Consultation Response from KC Lead Local Flood Authority		
2019/93444 land at former, Batley & District Cottage Hospital, Transvaal Terrace, Carlinghow Hill, Batley, WF17 0AA		
Partial demolition of existing building, alterations to convert retained building to 20 apartments and erection of 20 dwellings (within a Conservation Area)		
Date Responded: 27 November 2019	Responding Officer: Aleksandra Tomczyk	Responding Ref: 0

Kirklees LLFA reviewed the *Flood Risk and Drainage Assessment* document provided (prepared by Weetwood, v1.1, dated 7 October 2019), and provide the following comments:

Post Development Impermeable Area

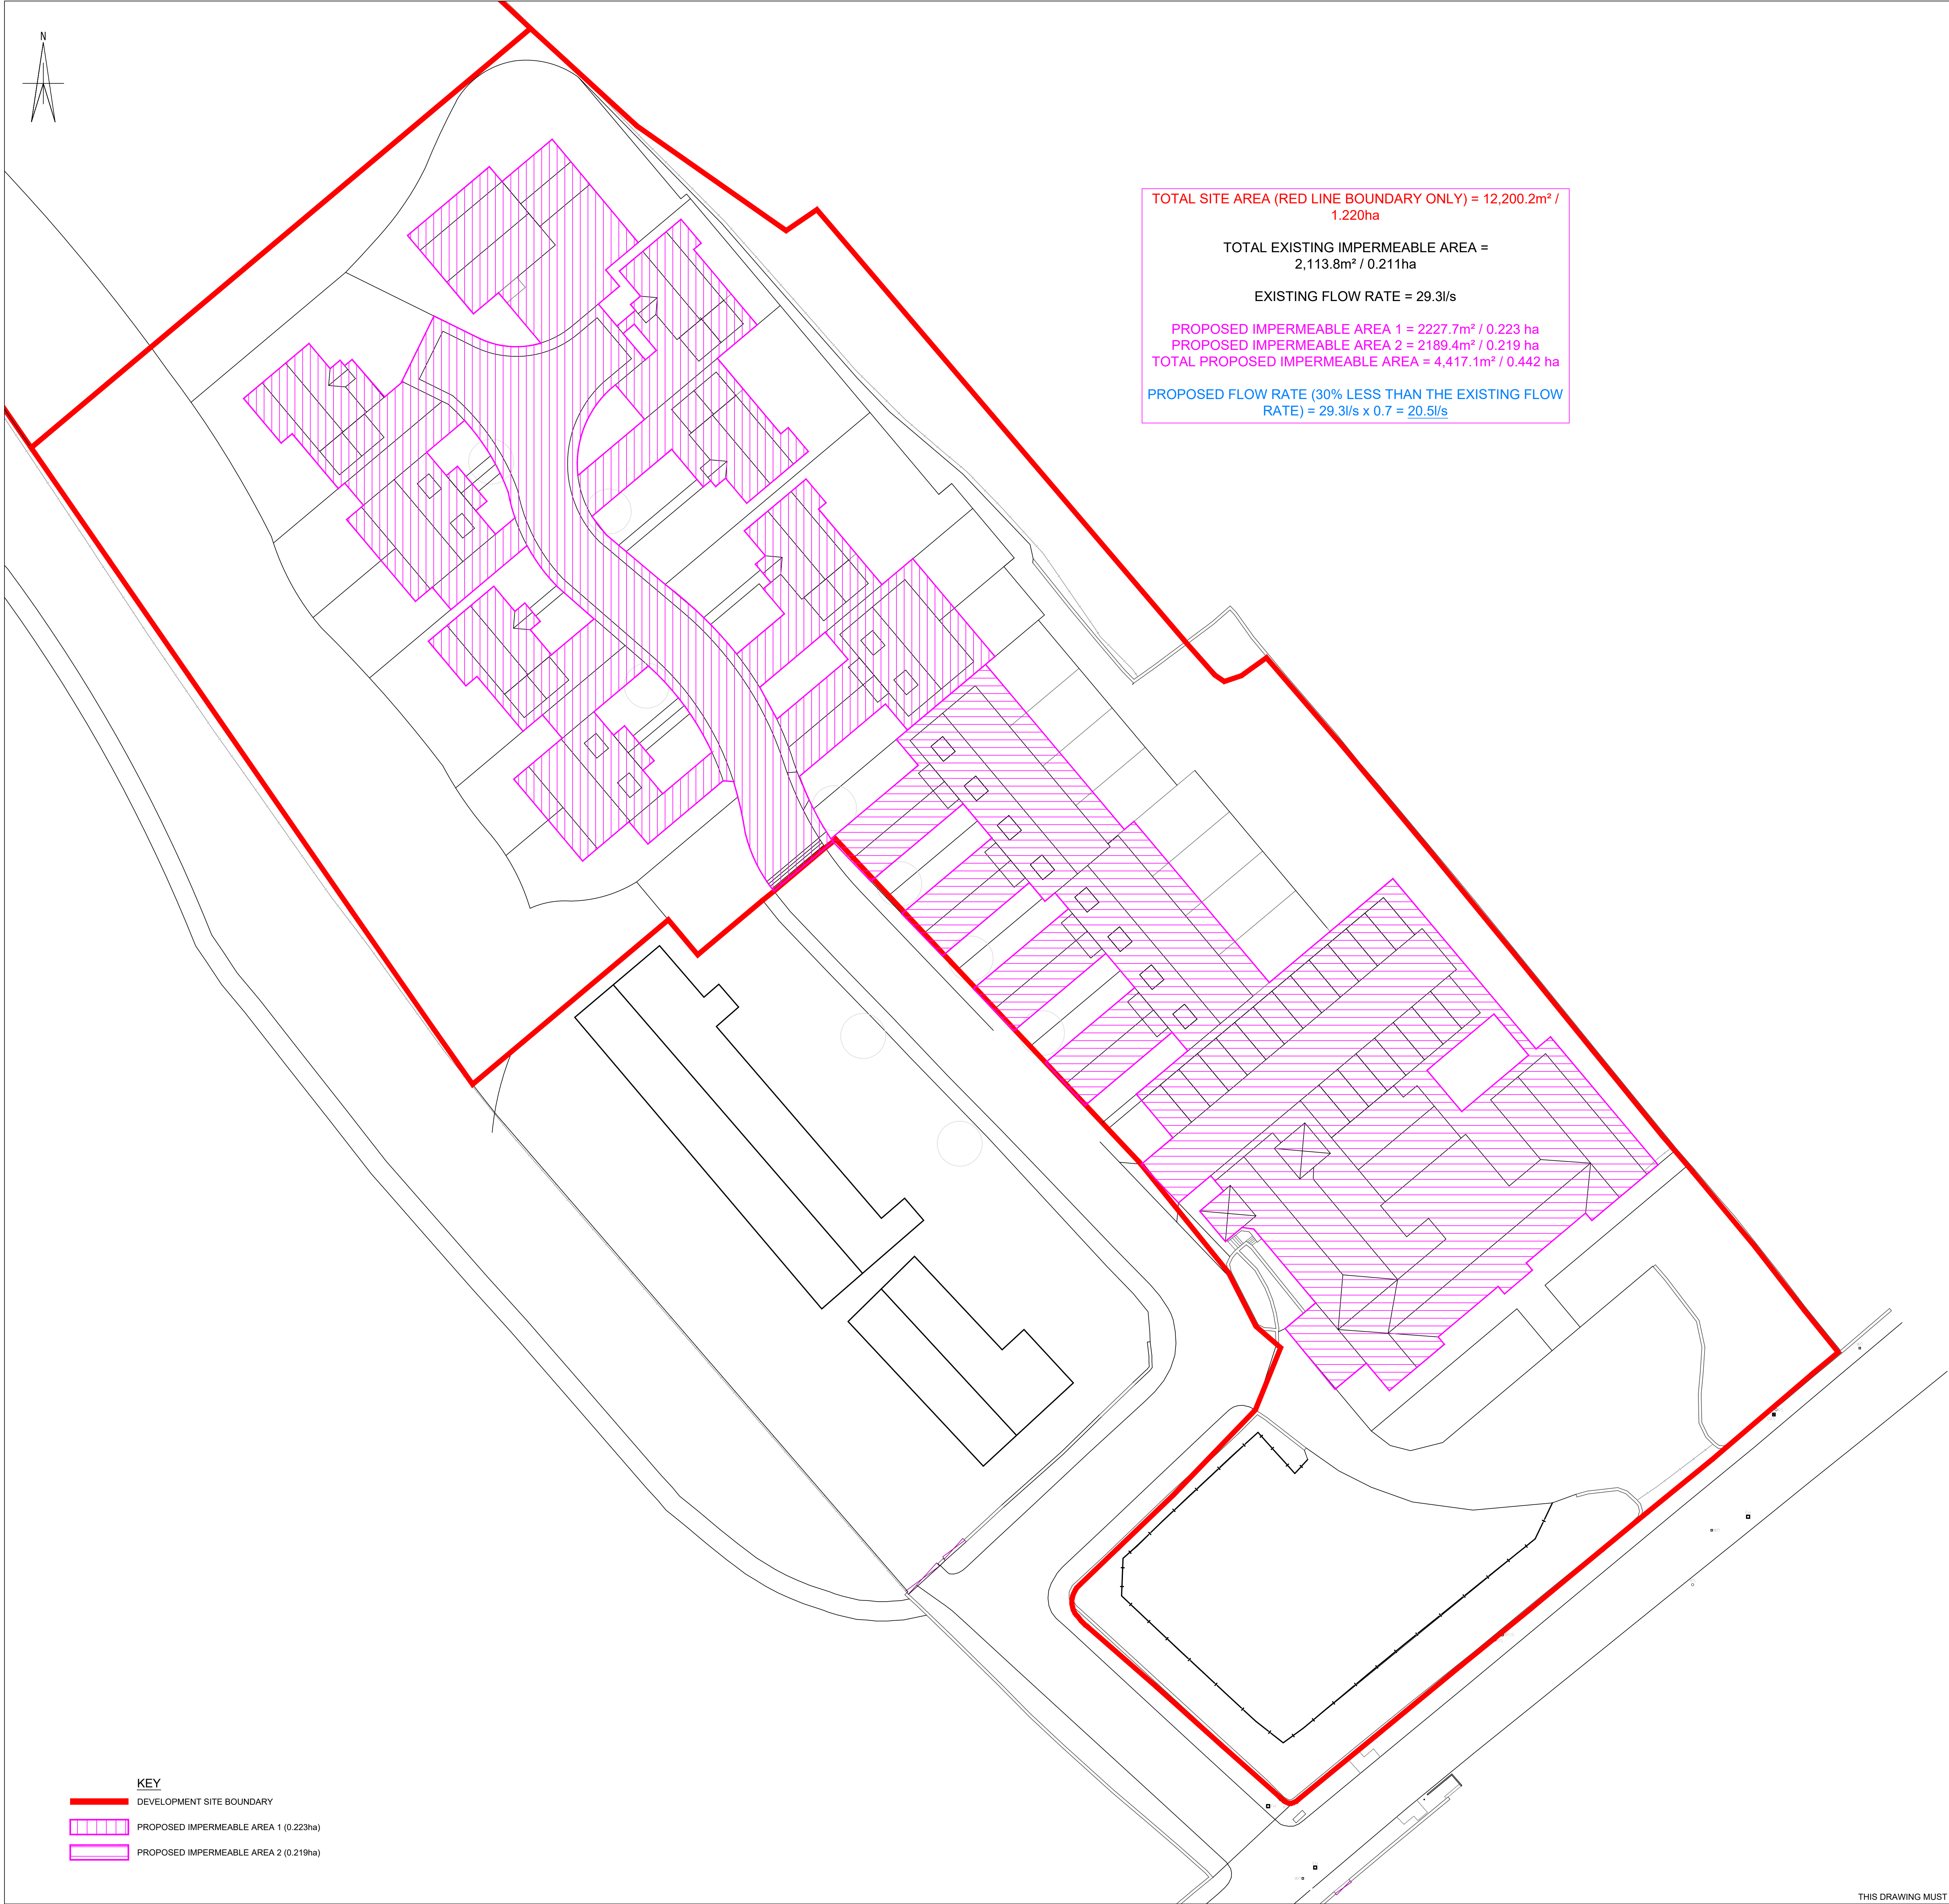
- The same section as above also specifies the attenuation storage for the Drainage Area 2 as permeable paving with sub base. This is specified as having a void ratio of 30%, which is the maximum available. Guidance states a void spacing of between 20-30% should be used for permeable paving. Kirklees LLFA suggest the applicant changes the specification of the paving to provide 20% void ratio instead, which is more likely to be feasible. Using the upper limit of 30%, the permeable paving would provide 60.4m³ of storage, while using a 20% void space would provide around 40.2m³. The difference in storage is approximately 20m³. Using this lower rate would be more suitable as it is likely that post construction, void spacing will reduce over time due to sedimentation, even with maintenance. Given that there is a known challenge in maintaining void spacing in permeable paving over time, as well as maintaining permeability, it is considered that a dedicated storage tank or similar may be a more pragmatic solution to achieve the surface water attenuation required.

Given that this is to be used for storage (with no indication of desire for infiltration), Kirklees LLFA would expect the system to be lined to prevent groundwater intrusion and sedimentation (unless it is demonstrated that infiltration is suitable). Similarly, the applicant will be required to ensure that the attenuation required is provided throughout the operation of the site, which may require significant maintenance.

- Considering the parking lot provides 21 parking spaces, Kirklees LLFA expect a petrol interceptor to be included in the design.
- *Appendix H – Surface Water Attenuation – Storage Volume Calculations* within the FRA submitted contain MicroDrainage output for the 1 in 100 year event + 30% climate change allowance. It is good practice to provide the 1 in 1 year and 1 in 30 year storm event outputs for review as well.
